**Application by Highways England for an Order  
Granting Development Consent for the A428 Black Cat  
to Caxton Gibbet Road Improvement scheme**

**Summary of Written Representation**

**Central Bedfordshire Council**

**August 2021**

Diversion route A1 Sandy to Black Cat

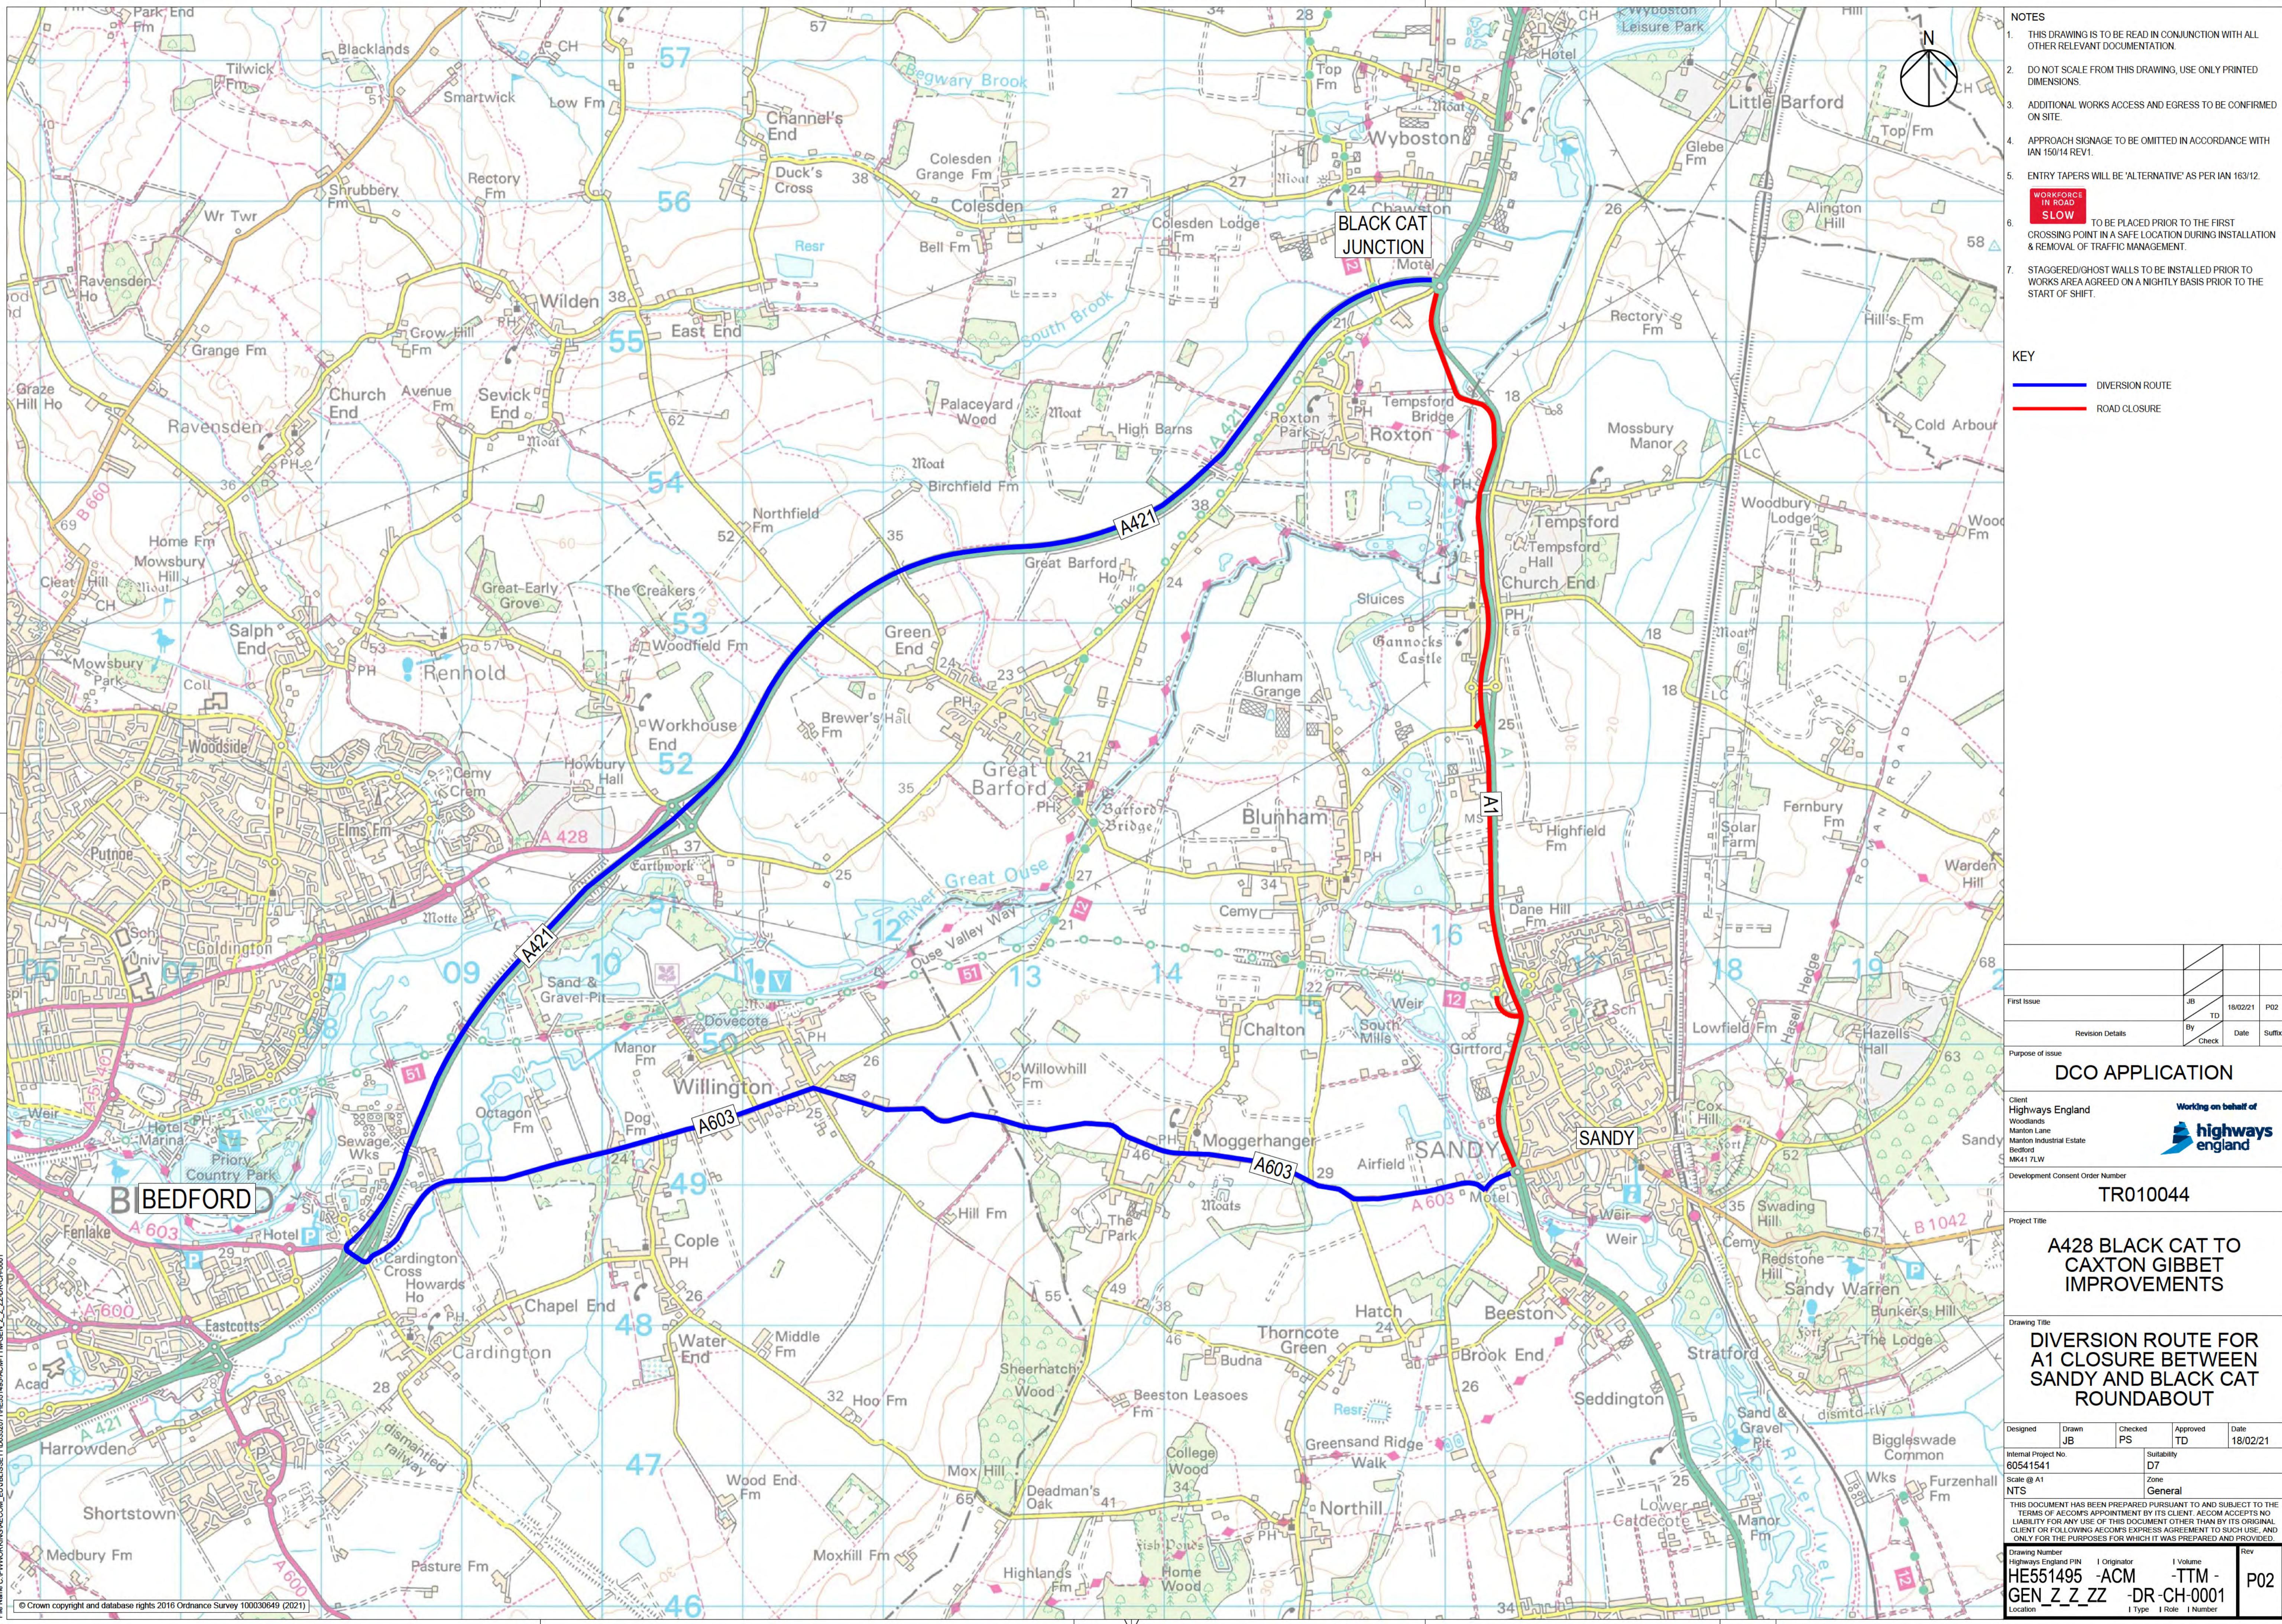
The A603, west of the A1 is identified within the Outline Construction Management Plan (APP-244) as being a signed diversion route when the A1 north of Sandy is closed to traffic. This route has a recognised road traffic collision history which may be exacerbated by increased flows, with the 1.2km section between Hatch Road and the centre of Moggerhanger having 12 recorded injury collisions, including 4 serious injury collisions, within the most recently available 5 years' data. The junction onto the A603 from Vinegar Hill is also known to be difficult for right turners, which will be the predominant flow for diverted northbound traffic. As such temporary or permanent signal control or other works are expected to be required to regulate traffic flows. As this junction is outside the confines of the DCO, CBC would welcome a discussion with HE to agree an appropriate contribution to deliver these works as part of the Development Consent Obligation or a S278 highways agreement.

Diversion route A1 Wyboston to Black Cat

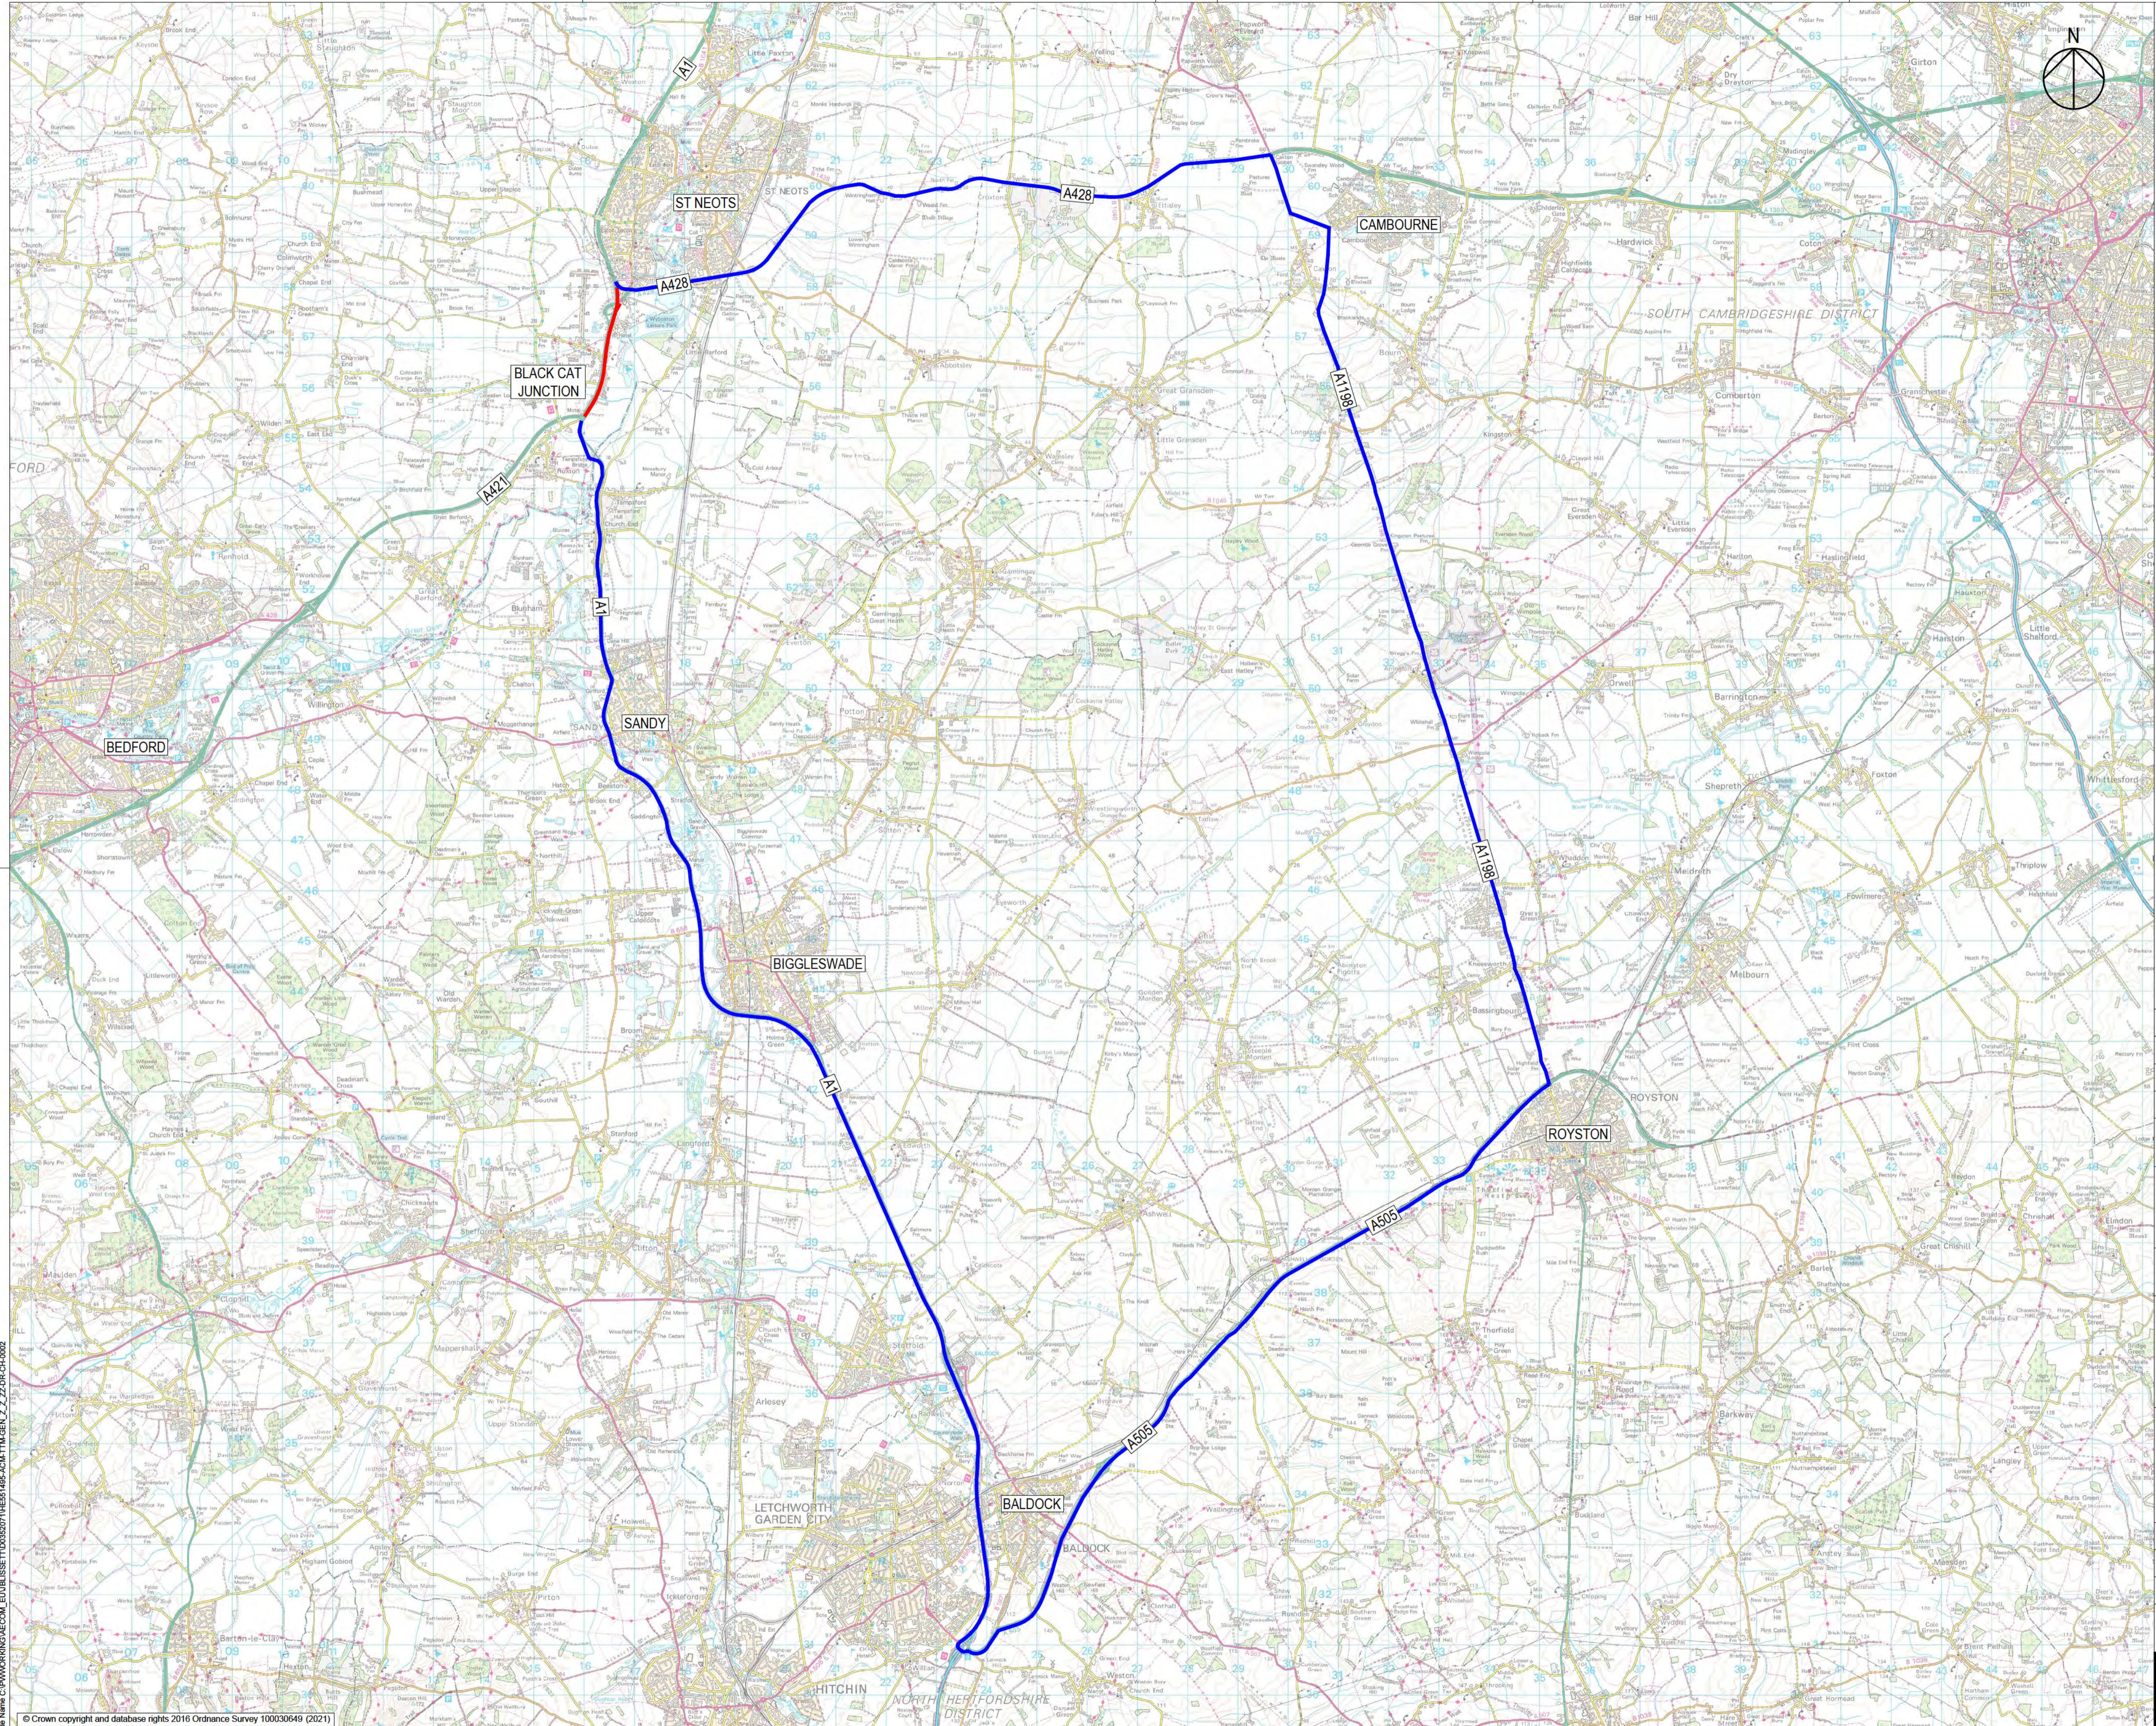
Due to the considerable diversion route for the Wyboston to Black Cat junction, traffic travelling between the A1 and the A428 is likely to select to route via Barford Road rather than following the diversionary route.
